Application No: EP/68/21/HH
Site Address: Merrydown Kingston Lane East Preston BN16 1RP
Description of works: Erection of timber framed detached garage with ancillary accommodation on first floor, installation of electric gated entrance, erection of new brick garden walls and extension to existing driveway and hardstanding.

OWQC38882

As the property is within the Elm Avenue, Golden Avenue (part), Kingston Lane (part) North Lane (part) East Preston Area of Special Character, the committee agreed to object to this Application on the following grounds.

DRAWING TITLE
**Proposed Driveway Gates & Wall
Planning Issue**

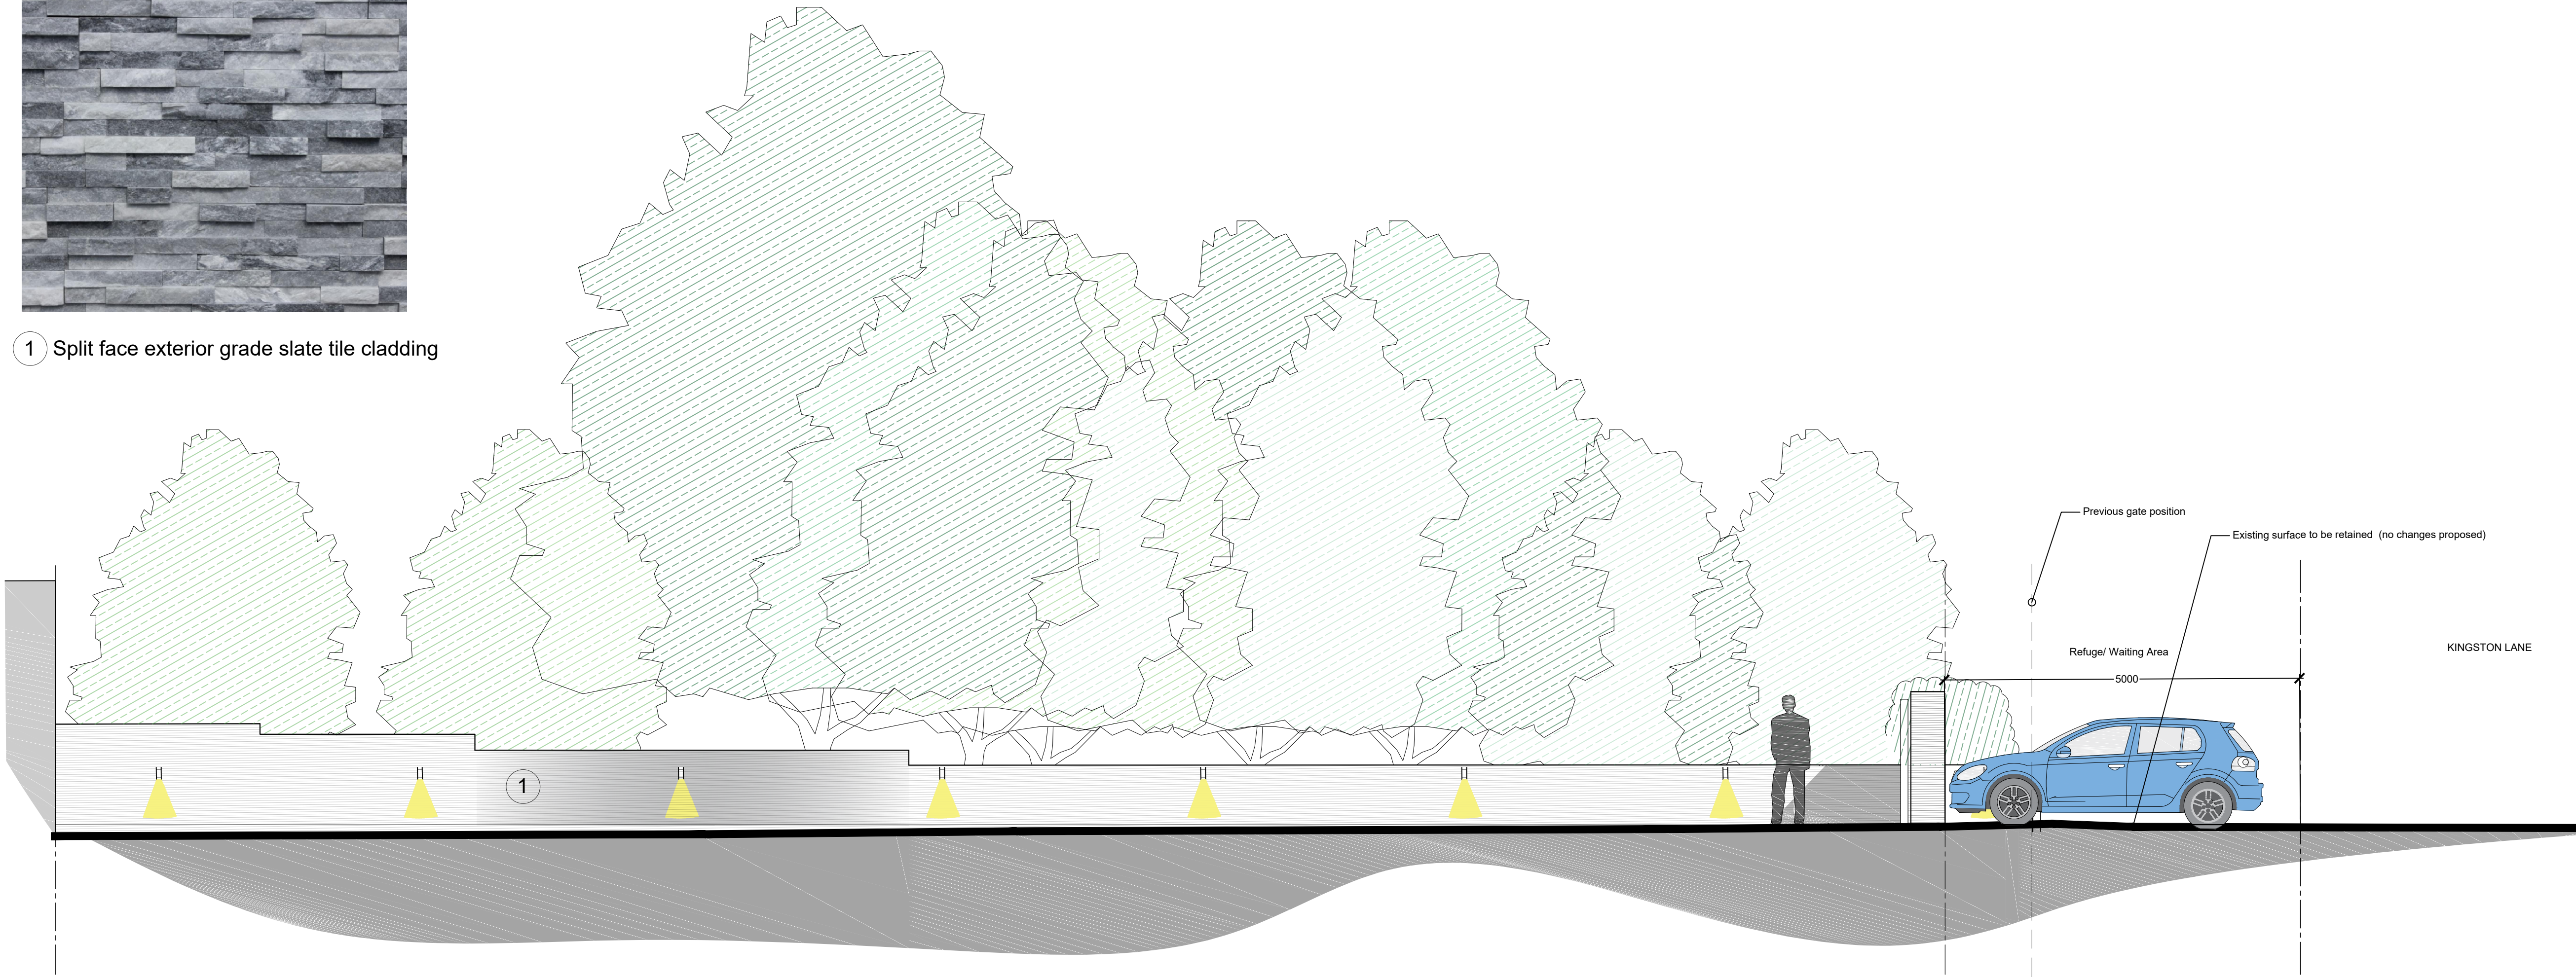
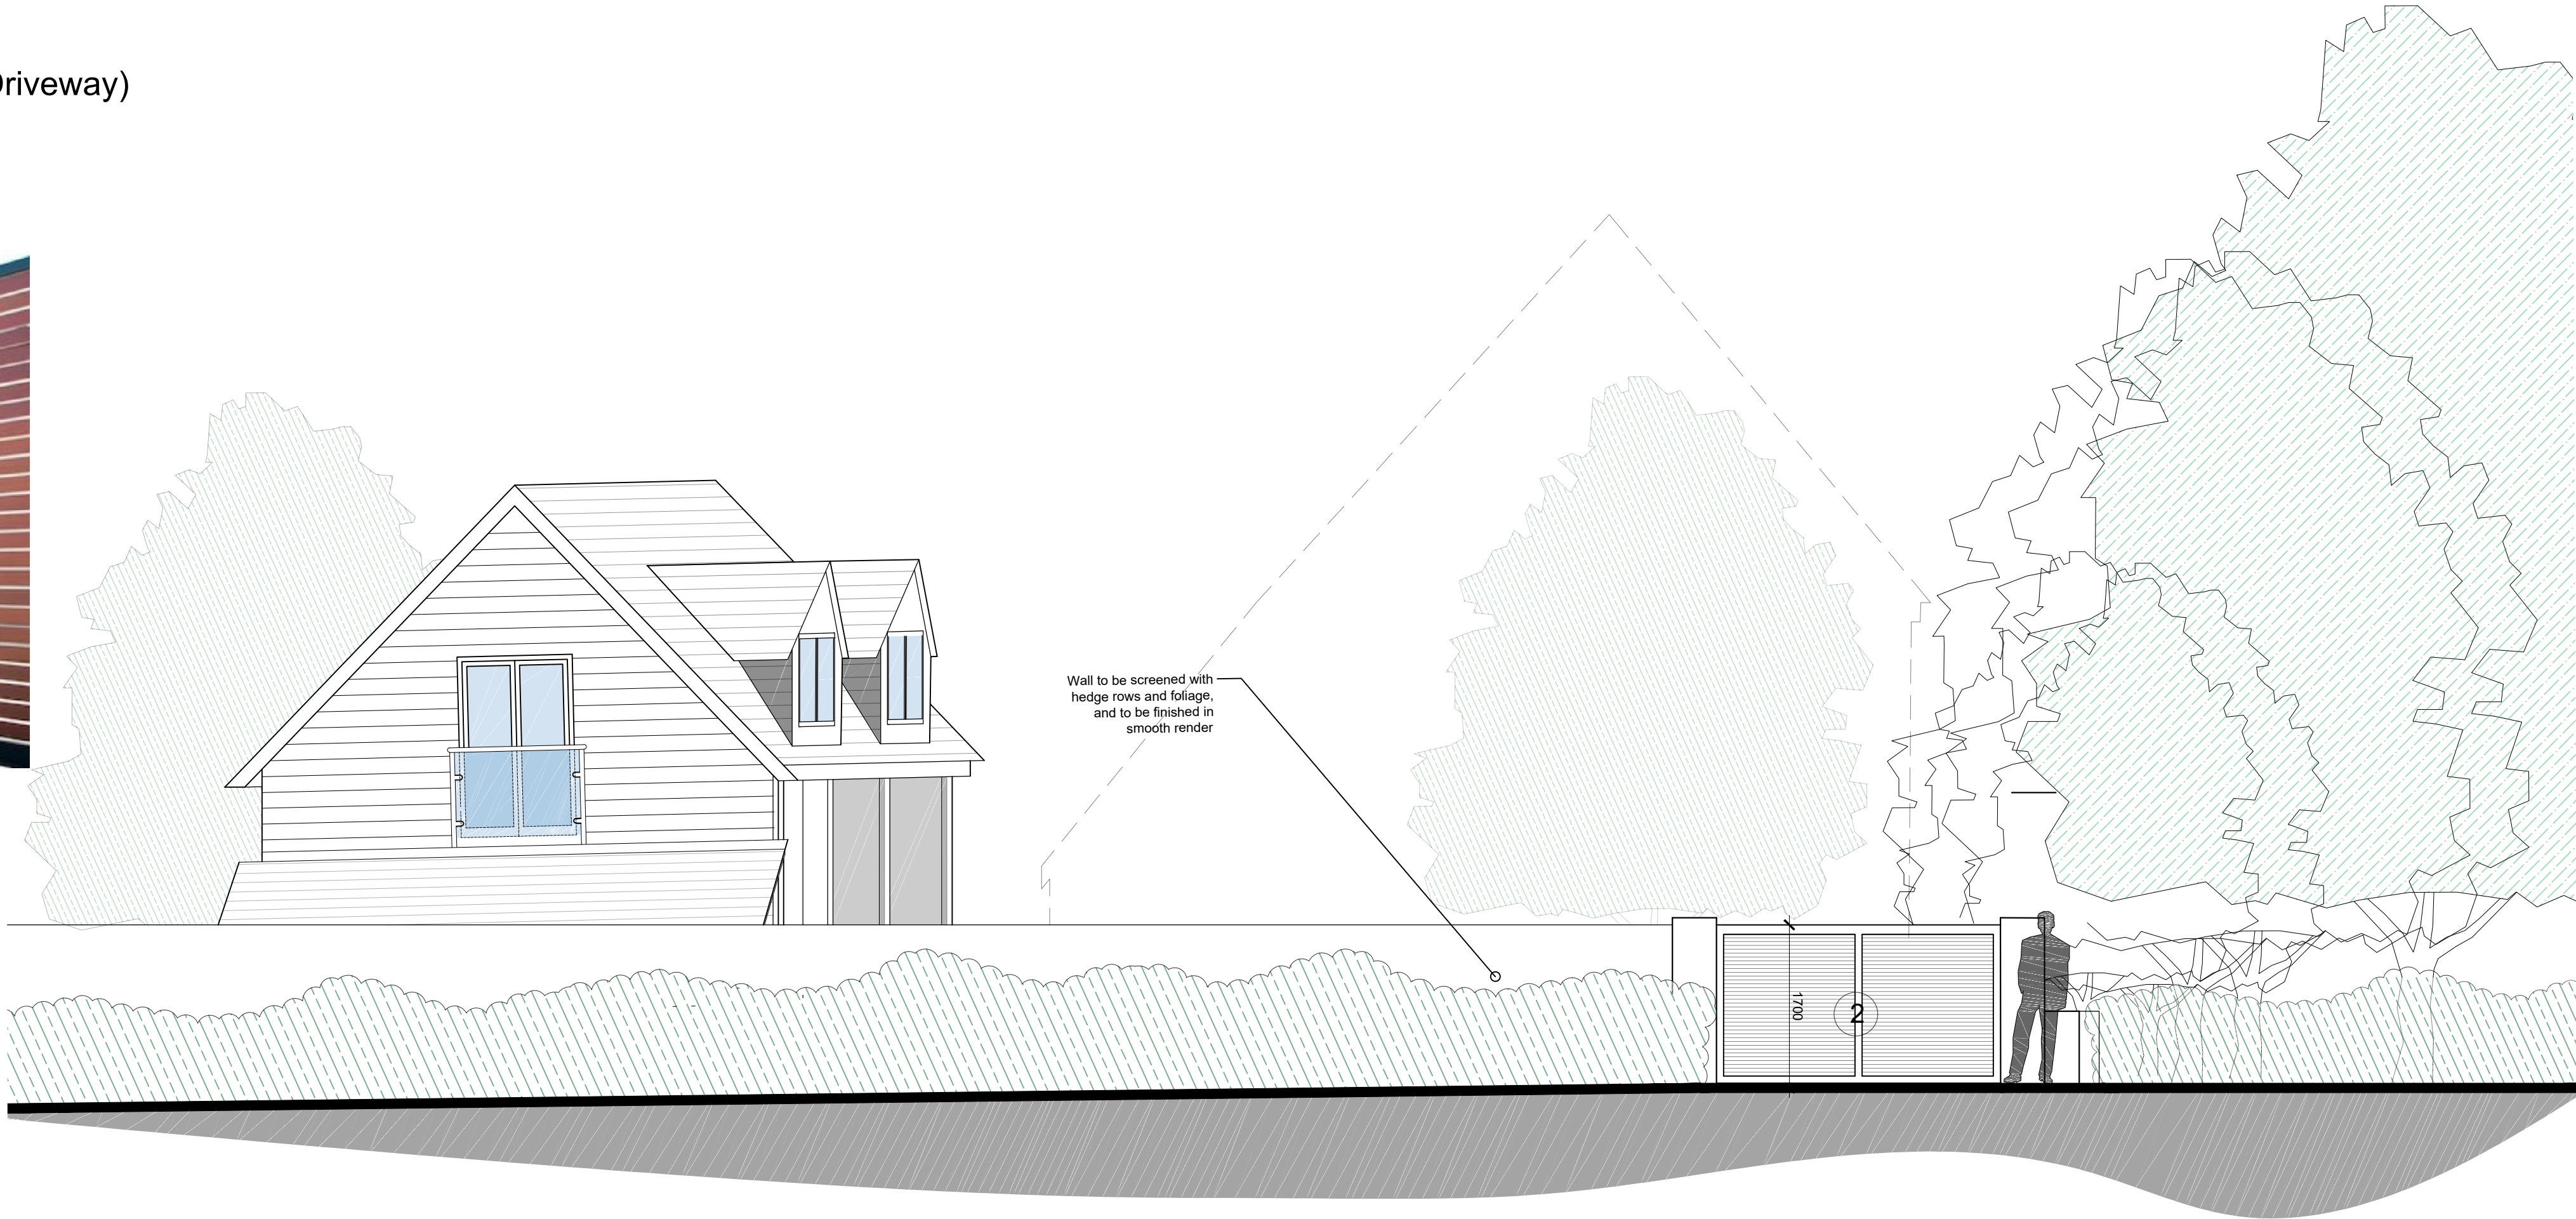
2. The proposed gate is very solid and not in keeping with the semi-rural setting of this property.
3. The proposed use of slate on the garage roof is out of keeping with the earth-tones palette of materials on nearby buildings and possibly also contrary to the semi-rural setting of this property.

4. The committee is concerned about the proposed height of the front wall at 1.7m, however accepts that it will be screened by the existing hedge. If it is possible to add a Condition relating to the retention of this hedge or future replacement with a similar height fence, that would be appreciated.
